SUBJECT: Engineering Review Comment  
Mountain View Electric Association Inc. (MVEA)

**Project Name: Skye Vista Subdivision – Final Plat**  
**Project Number: SF2434**

**Description:** Proposed development of 13, 2.5-acre residential lots and 2 tracts located north of Hodgen Rd. and south of Settlers Ranch Rd. in Township 11S, Range 66W, Section 23.

SKYE VISTA SUBDIVISION FILING NO. 1

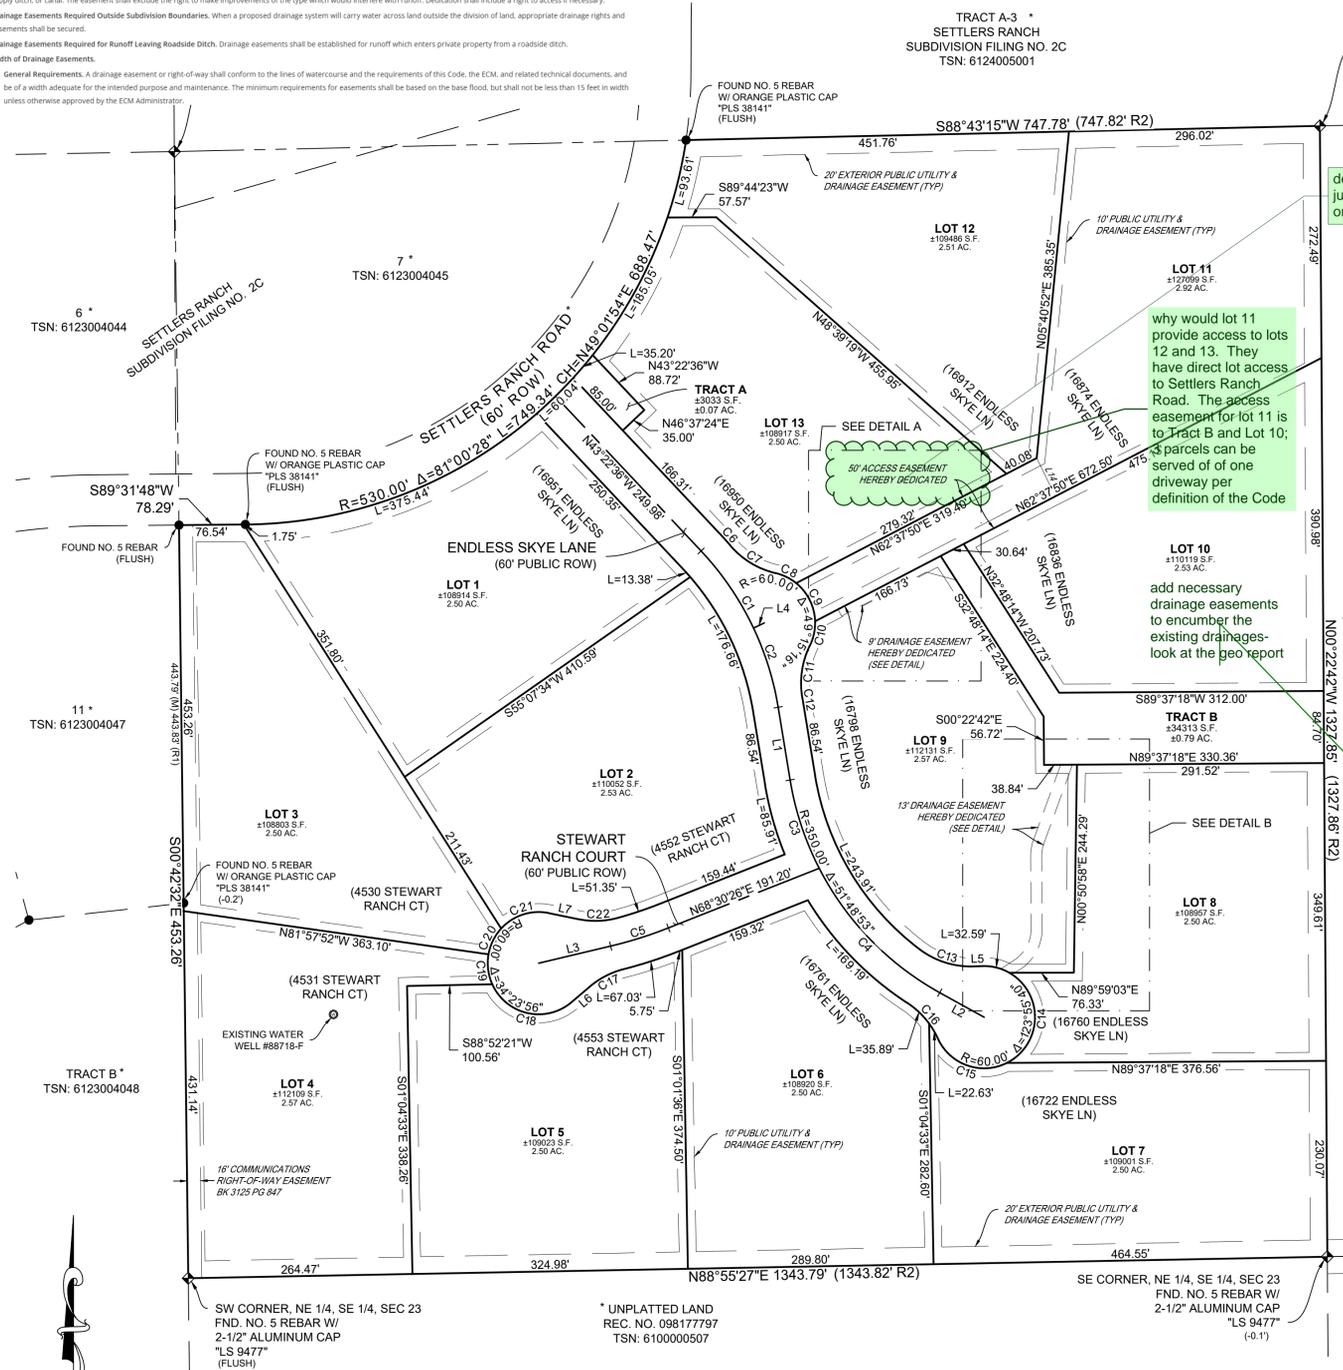
MVEA requests a ten (10) foot front, side, and rear lot utility easement and all tracts, along with a twenty (20) foot exterior utility easement on the plat. MVEA also requests the platting of MVEA's existing facilities with easements on the plat. Additional easements may be required.
